SSD-13475973 - Mowbray Road Data Centre – Public Submission

This submission focuses aspects of the 'Clause 4.6 Variation Request to Clause 4.3 of LCLEP2009 by Willowtree Planning on behalf of Microsoft.

**Figure 2 Height Plane Diagram from the Southwest Aspect** (Source: Greenbox Architecture, 2022)

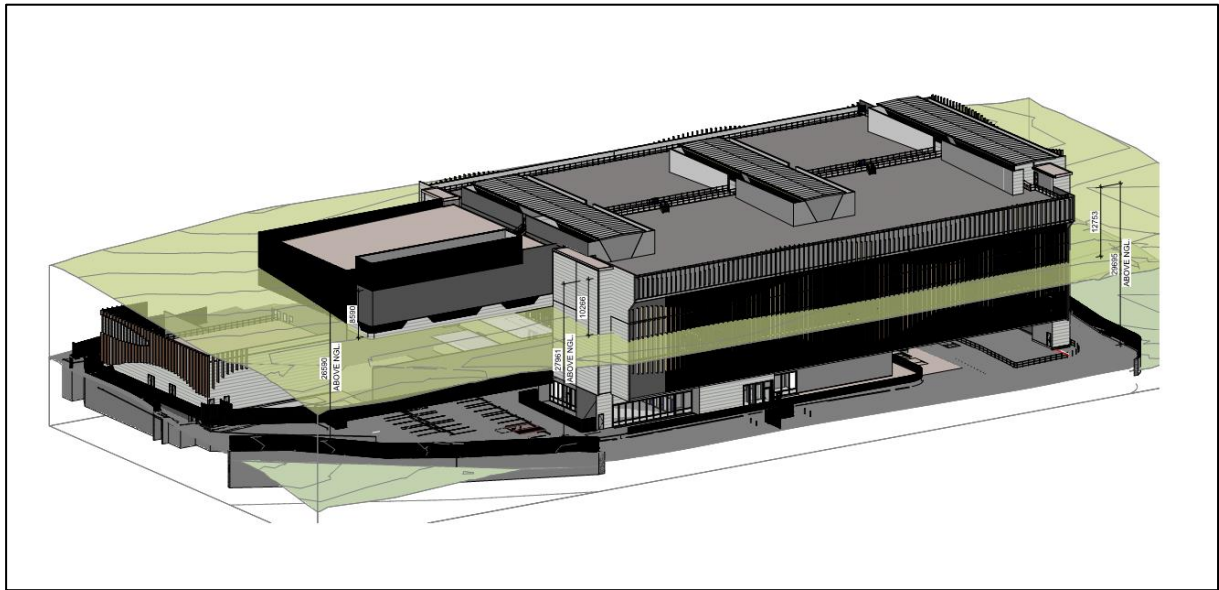
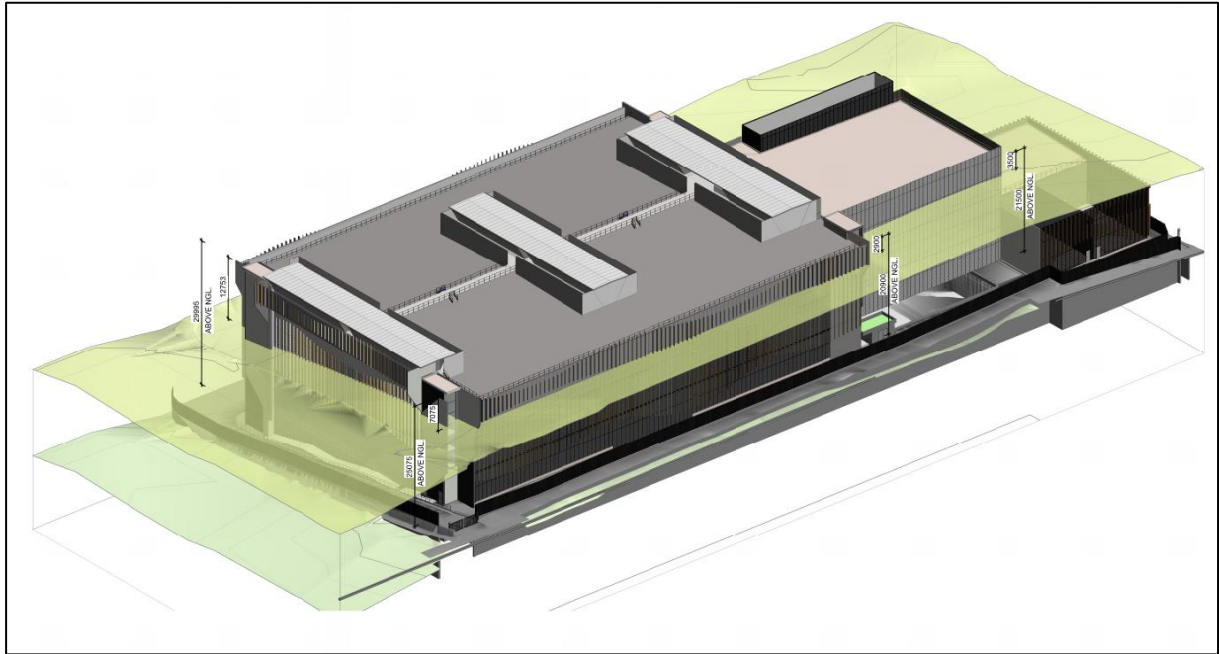
1.2 pg5 *The height plane diagrams demonstrate that the Data Centre is broken down into one (1) main building, with the heights (varying from 26.59 m – 29.695 m) being positioned at the rear of the Site to ensure that potential visual impacts are further mitigated by positioning the built form as far away from the streetscape as possible. The front of the Site (varying from 20.9 m – 25.08 m) is much closer to the streetscape; however, is coupled with increased landscaping to assist in screening the bulk and scale of the Proposal ...the highest points of the proposed built form are positioned at the rear of the Site. Along Mowbray Road West, the highest points will be between 20.9 m (16.11% variation) and 25.08 (39.33% variation).*

There is minimal attempt to ensure that the visual impacts are further mitigated from Mowbray Road. There is no tiering or stepping back & up from the height control at the Mowbray Road frontage.

Figure 4 Proposed Northern and Eastern Elevations (Source: Greenbox Architecture, 2022)

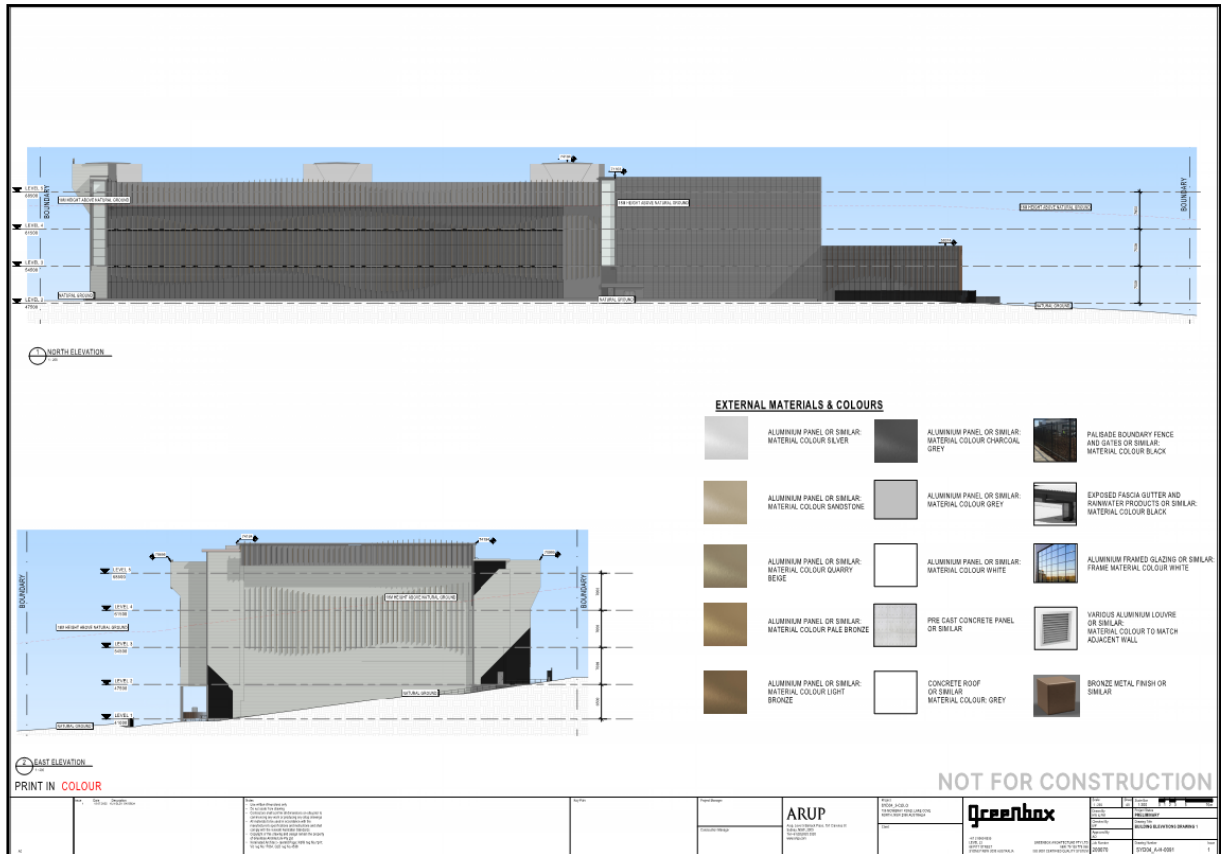
East Elevation

Landscaping is decreased compared to the existing environment with mature trees fronting Mowbray Rd which will mostly be removed. Even the existing mature trees would not sufficiently screen the proposed bulk & scale of the proposal. Increased landscaping will require 10years+ of growth.
